**Re: SSD 7543 Private Hospital and  
SSD 8499 Tower B at 12 Frederick Street, St Leonards**

#### **SUBMISSION TO SSD 7543 APPLICATION NORTH SHORE PRIVATE HOSPITAL - 12 FREDERICK STREET ST LEONARDS**

12 FREDERICK STREET, ST LEONARDS
LG2 LOADING DOCK
SWEPT PATH ASSESSMENT

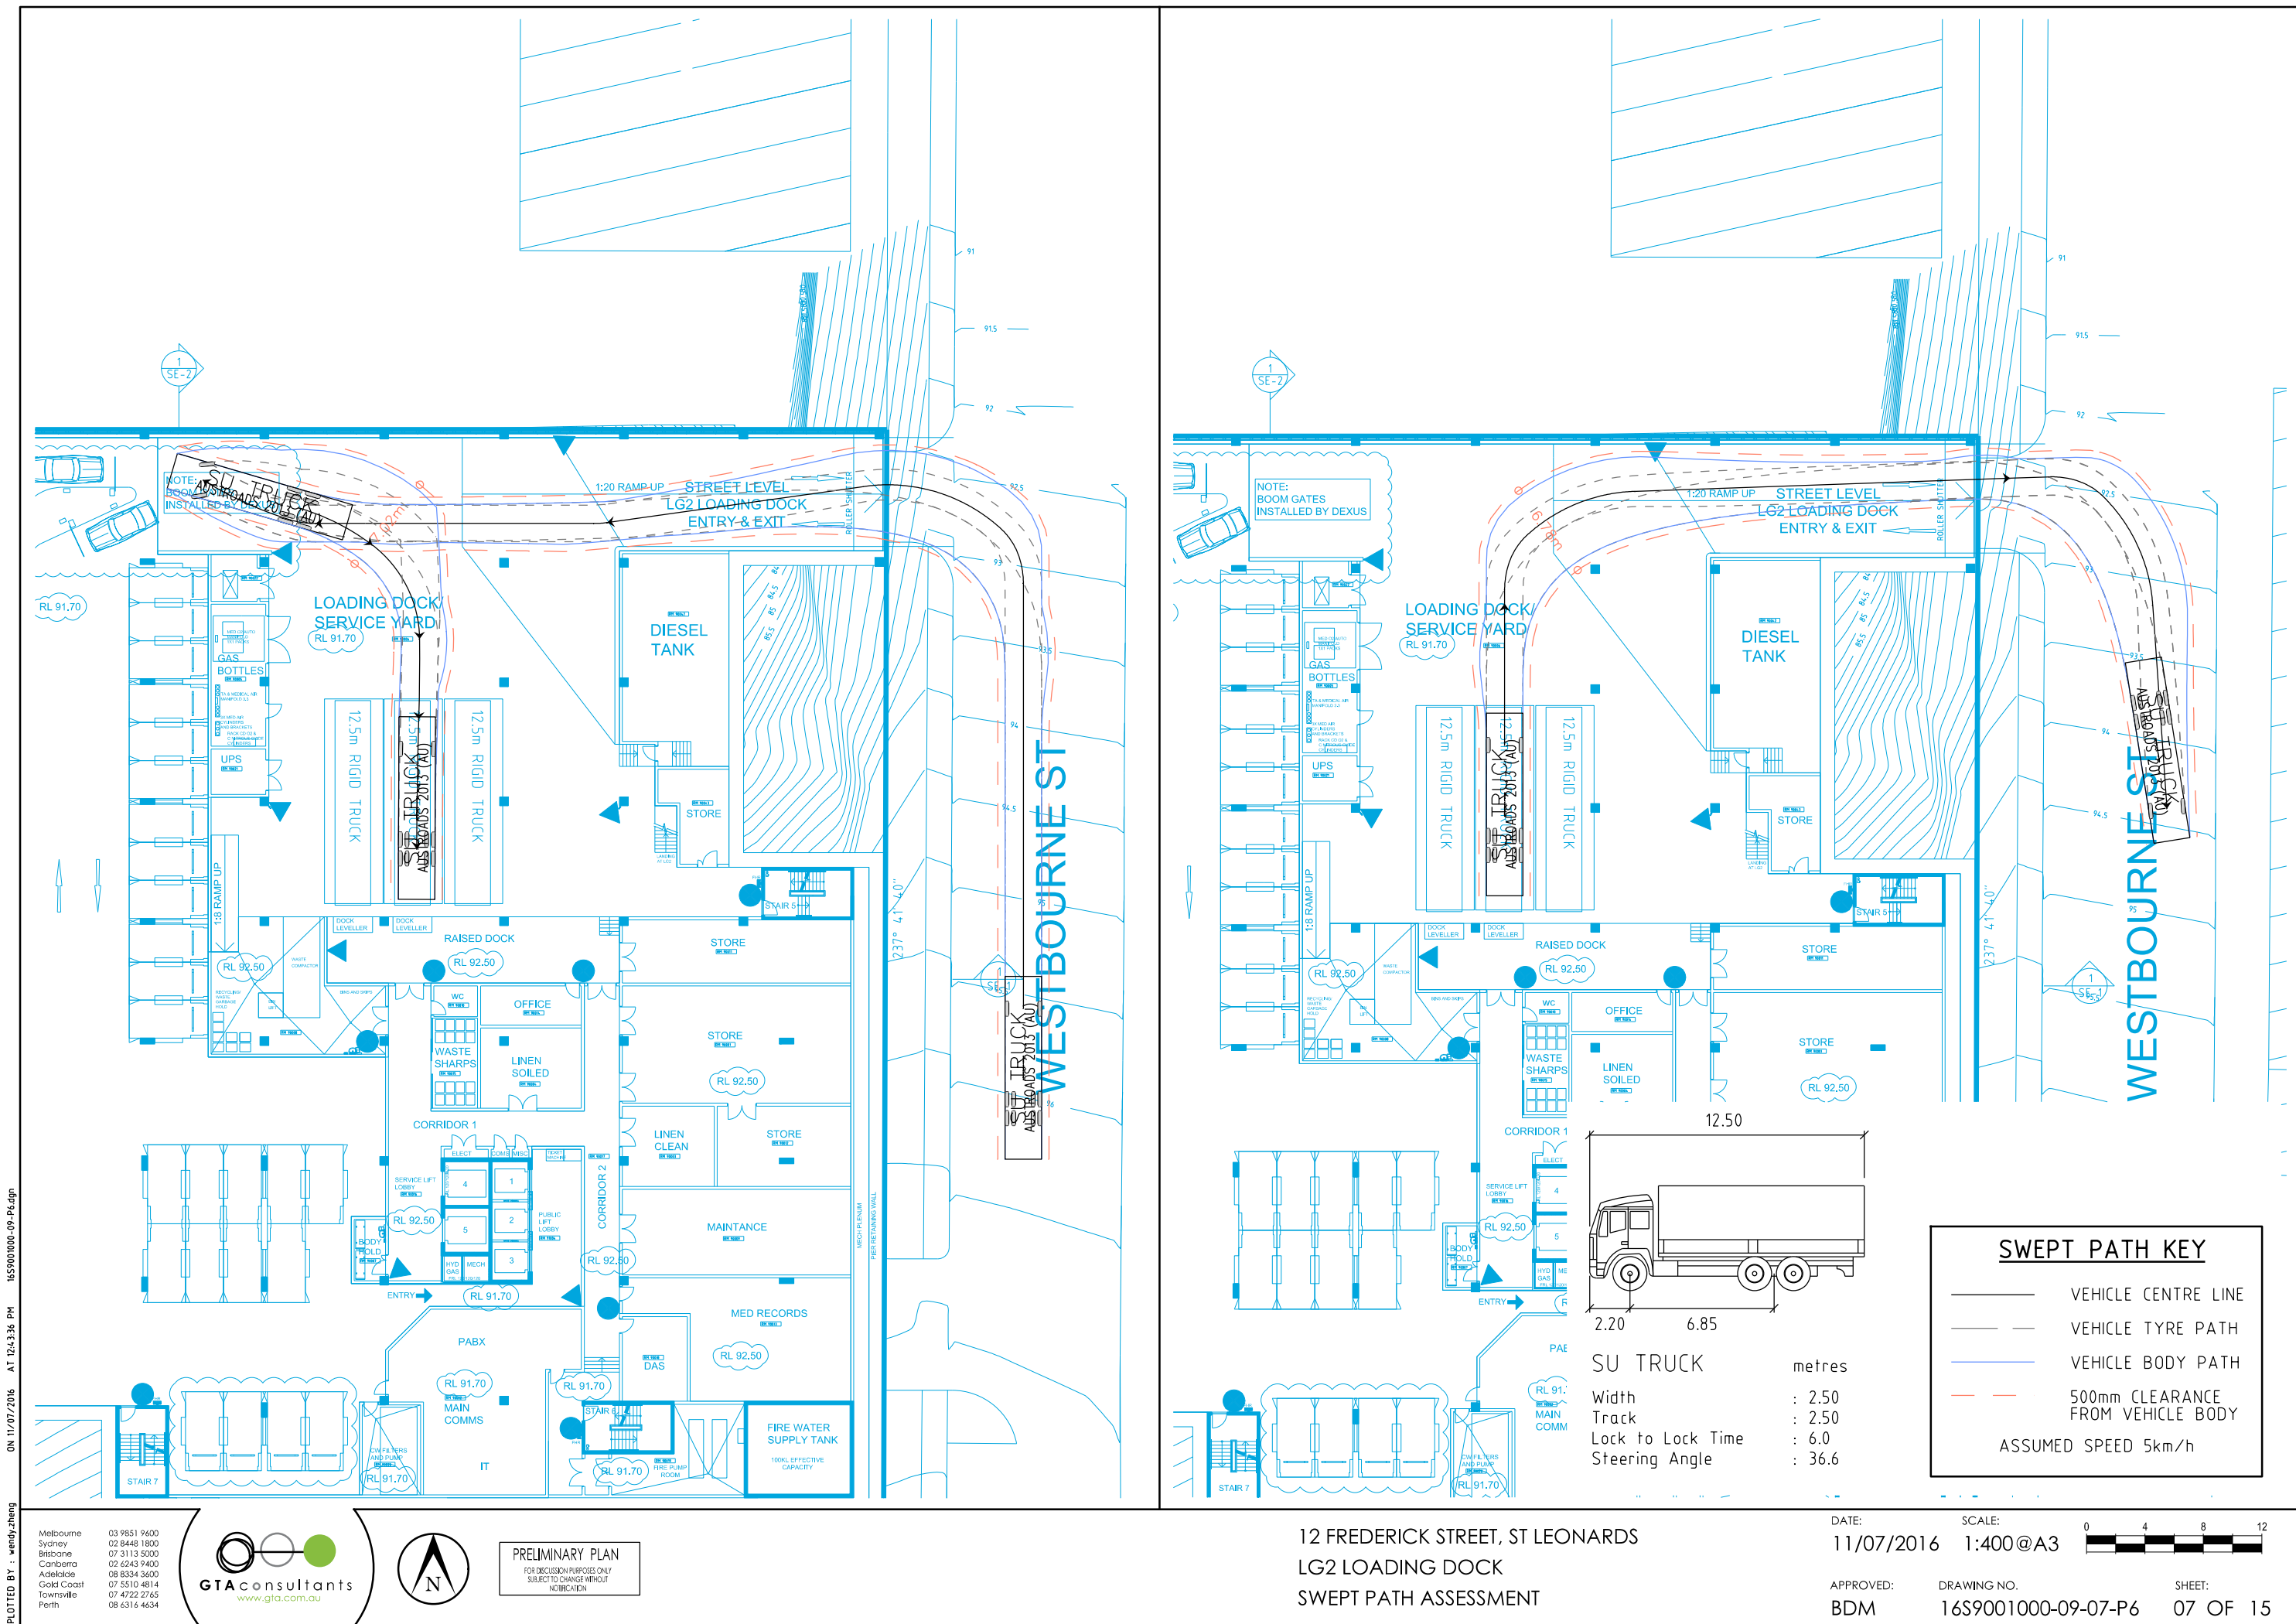
- > The TIA modelling is based on 45% private car use. However, no evidence is supplied to support this mode split from local surveys.
- > From swept path analyses the TIA identifies issues with 12.5m HRV vehicles manoeuvring on the site to and from the loading dock. Evidence that these issues have been resolved in the final design is required. GTA recommend that further resolution of the car park access control point and interaction with both the car park and loading dock is required.

- That a survey of the existing traffic volumes and transport mode split of the existing North Shore Private Hospital be undertaken to validate the traffic generation and travel mode assumptions on which the TIAs are based prior to determination of the Application.
- That the architectural plans be amended to address the issues identified with the loading vehicles prior to determination of the Application.
- That the architectural plans be reviewed to reduce the number of on street car parking spaces lost by the proposed development, particularly disabled parking spaces.
